MEMORANDUM

DATE: January 25, 2019
TO: Gabe Sevigny, PCD-Project Manager
FROM: Steve Kuehster/Jeff Rice, PCD-Engineering
SUBJECT: PPR-18-040 – Freedom Springs
Third Submittal

Site Development Plan

# SITE DEVELOPMENT PLAN

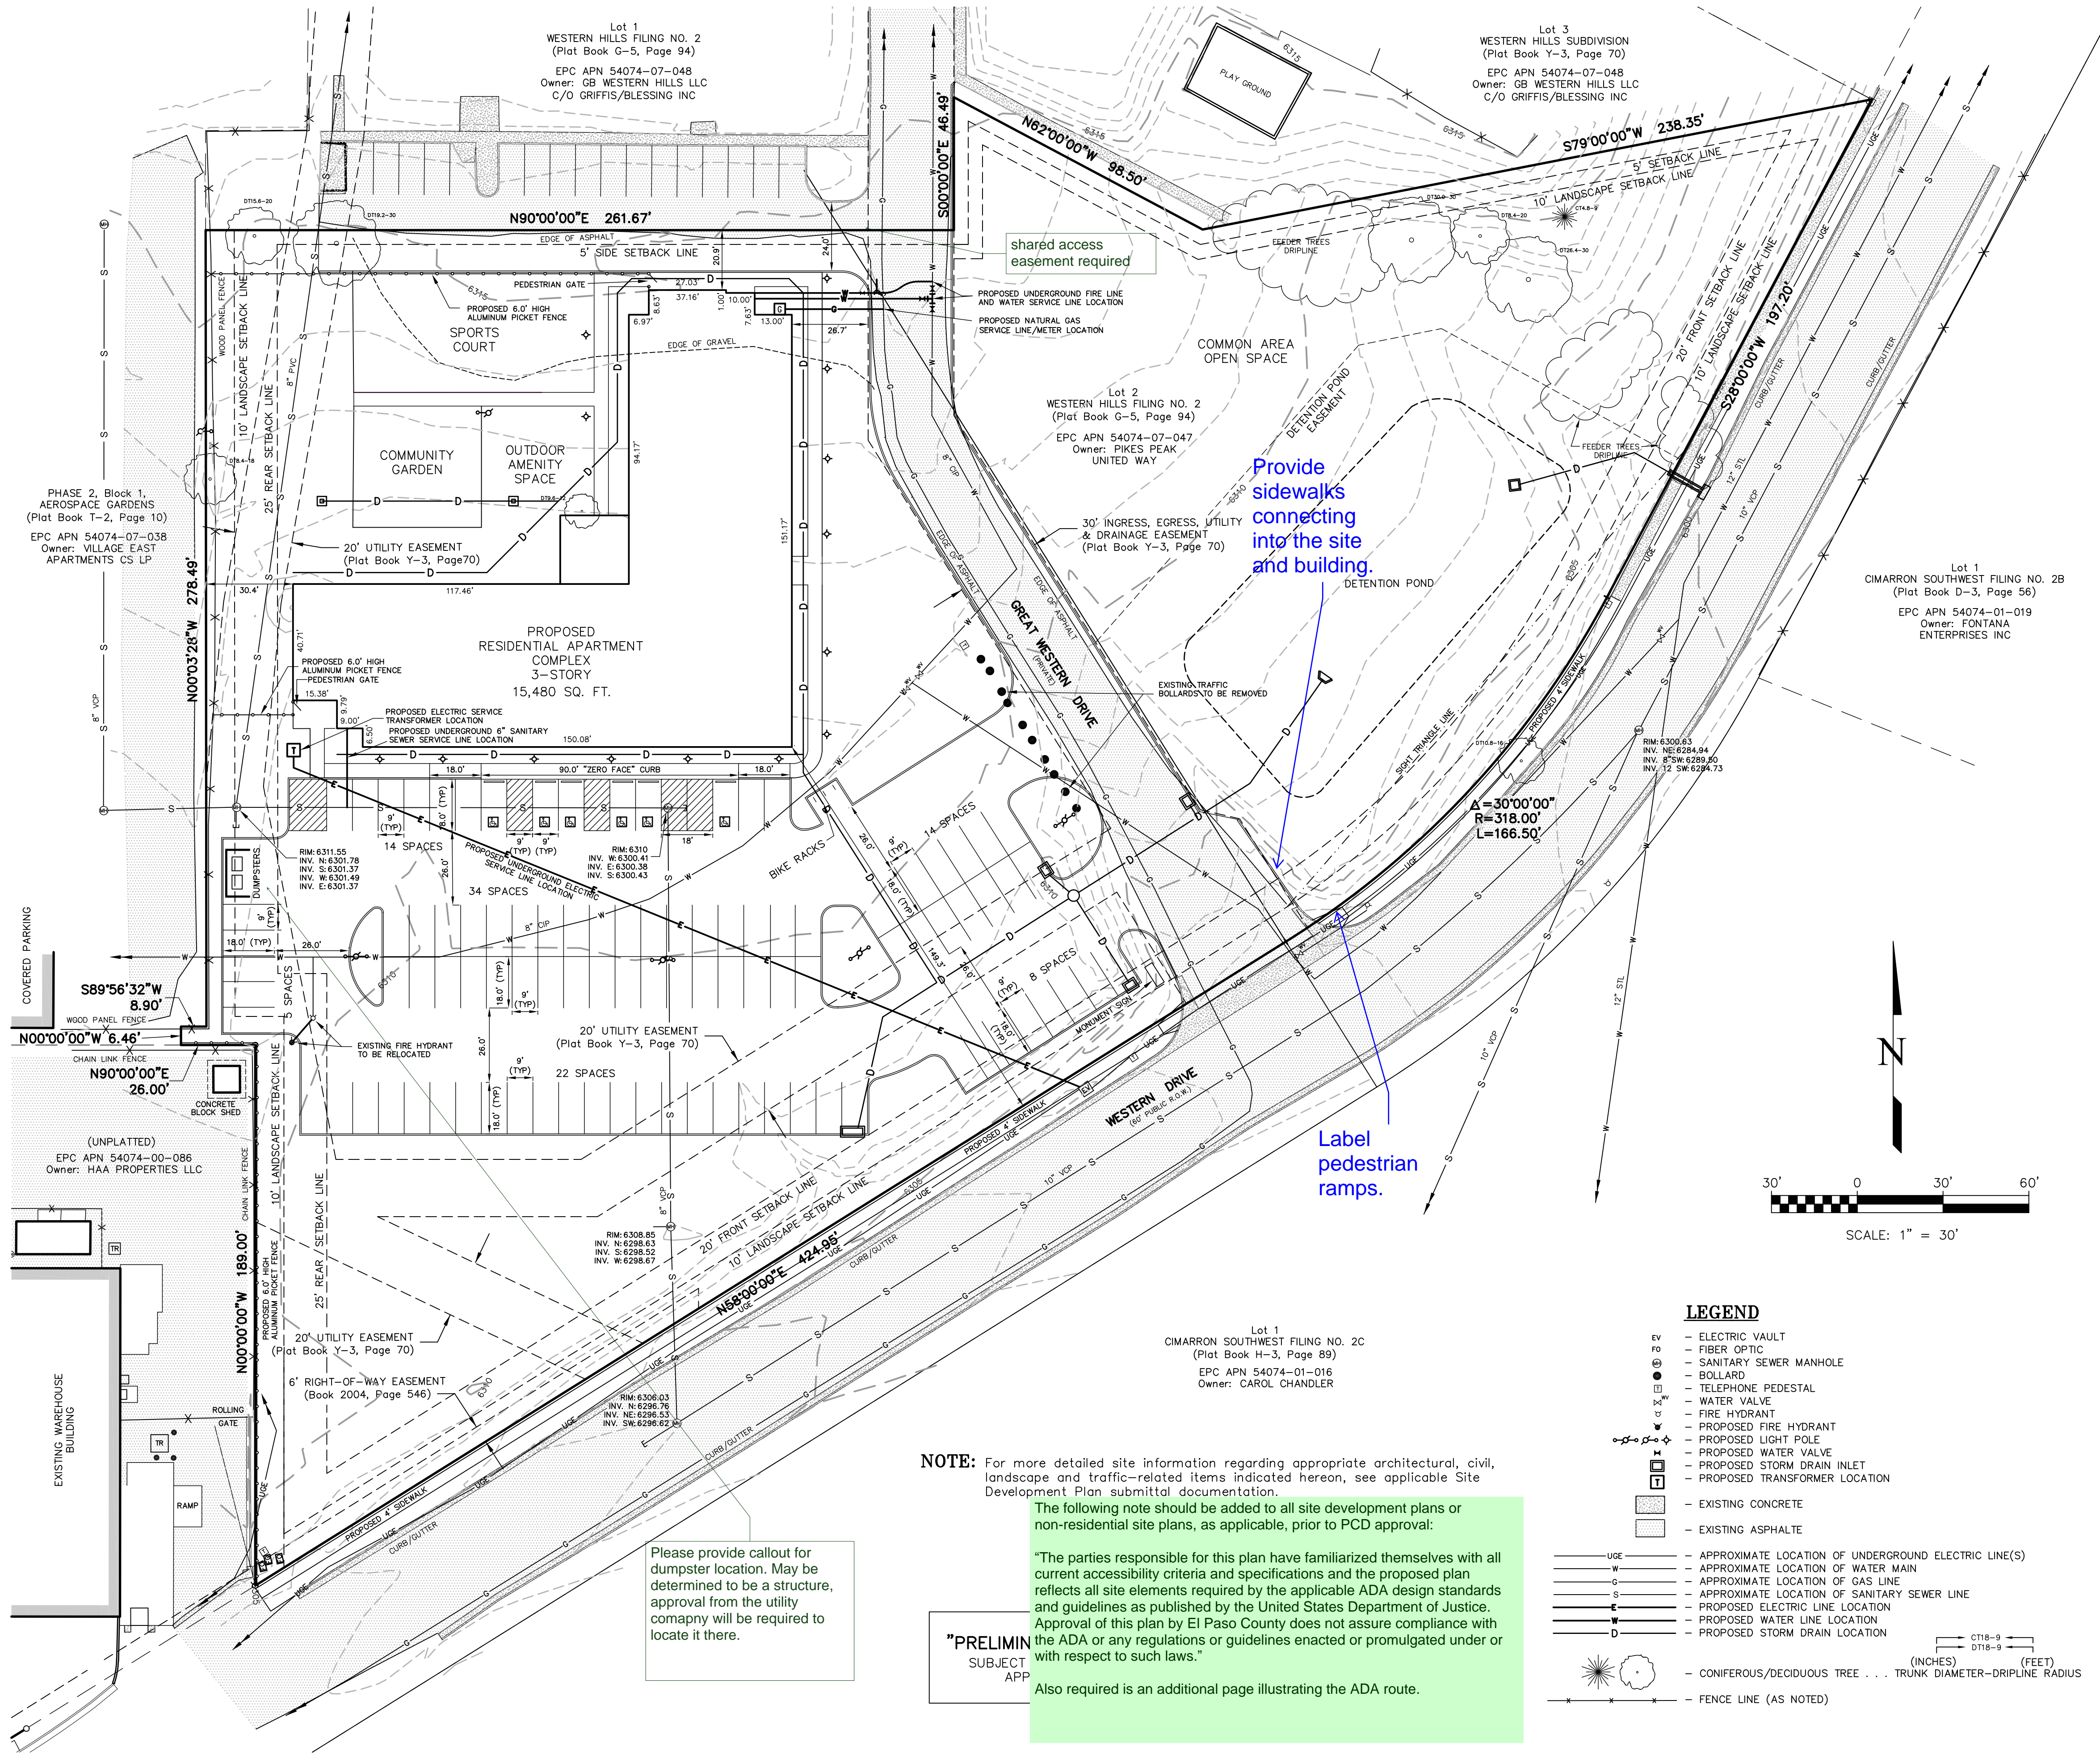
1. See Site Development Plan redlines. Partially resolved; see updated redlines. The sidewalk entering the site does not appear to meet ADA requirements. **Partially resolved; see remaining redline (note on sheet 1). If the note is acceptable and there are no further revisions it can remain (without a resubmittal) for approval ... Landscaping Note added to both the Site Development Plan and Landscape Plans – DVH**
